**Our Reference** 60468641 231488FUL Old Wood

**23/1488/FUL Land South Of Old Wood, Skellingthorpe: Review of Ecological Constraints and Opportunities**

Figure 1: UKhab Habitats and Features of Land by Old Wood, Skellingthorpe. 6th August 2022

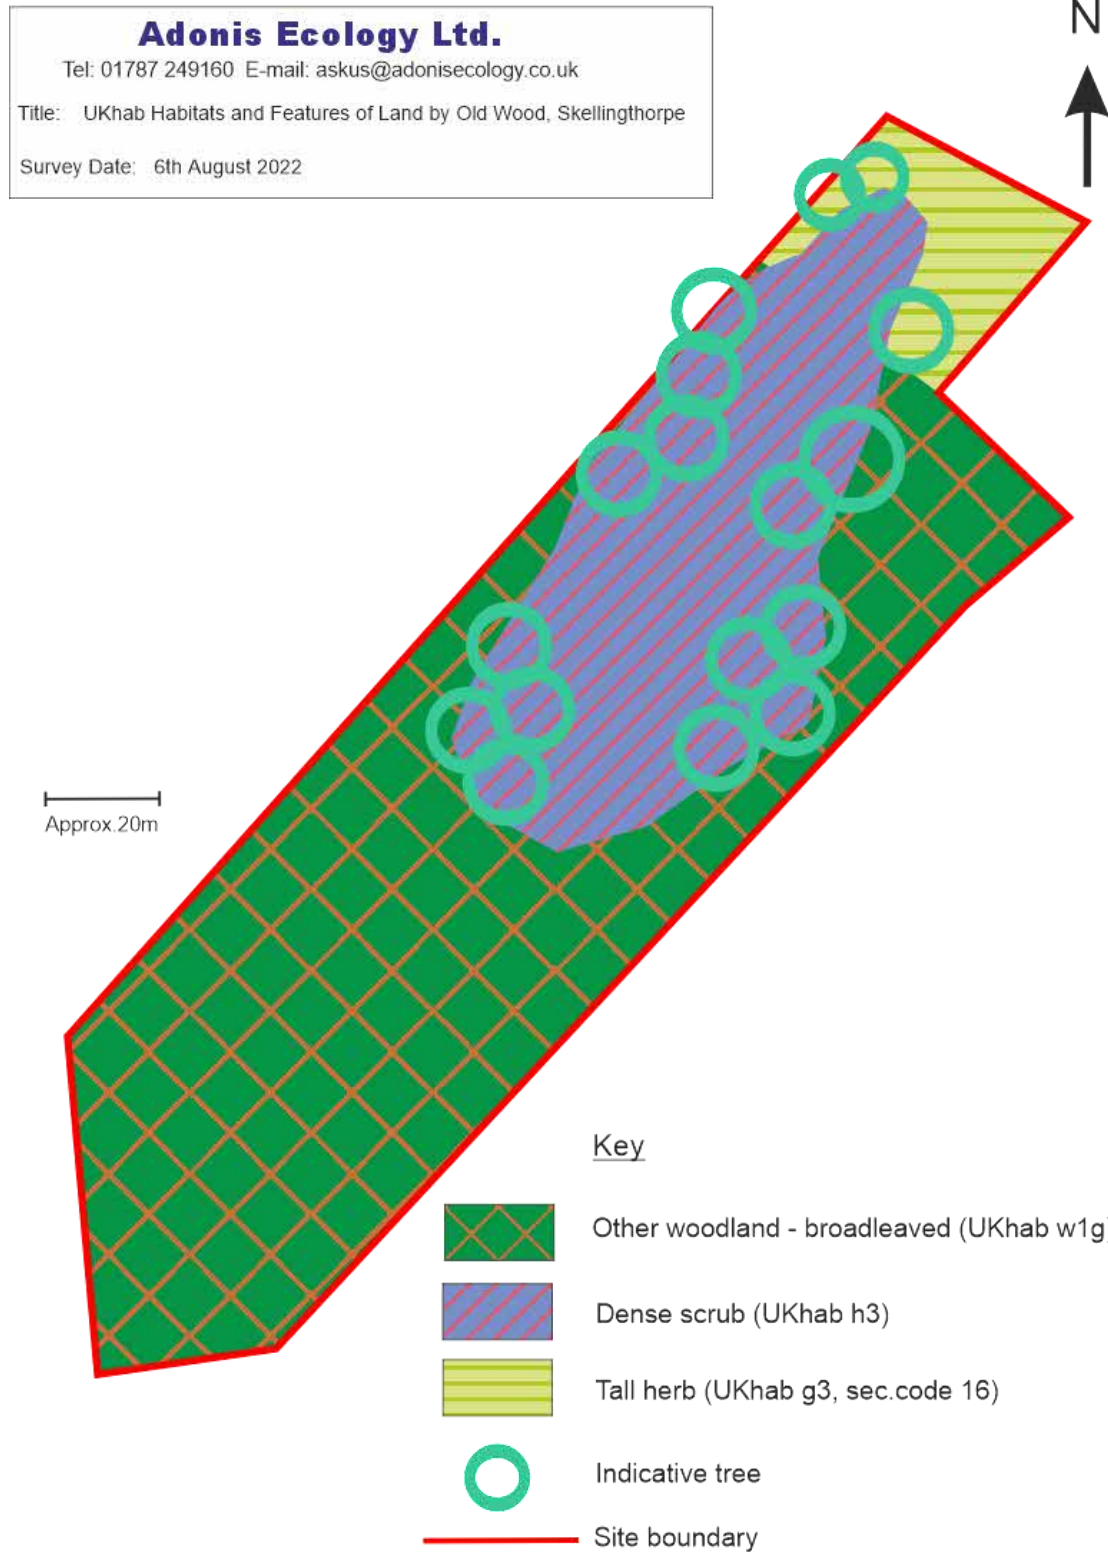
The MAGIC database and Ordnance Survey mapping identifies the site as woodland of a priority habitat type. The ecology report, which is based on survey work in August 2022, clarifies that most of the site contains weedy grassland of relatively low nature conservation interest. However, this is not incompatible with the presence of woodland, as woodlands are not defined by the presence of a closed canopy and they often contain clearings and rides of variable permanence. The general impression of the site from Google Earth, Streetview and the applicant's ecology report is a site set within the context of woodland, with periodic management/lack of management that influences the balance of tree cover over time. Policies S60 and S66 are therefore of potential relevance to determination. It should be agreed with the Tree Officers, who likely will have seen the site firsthand, whether the site should be considered woodland.
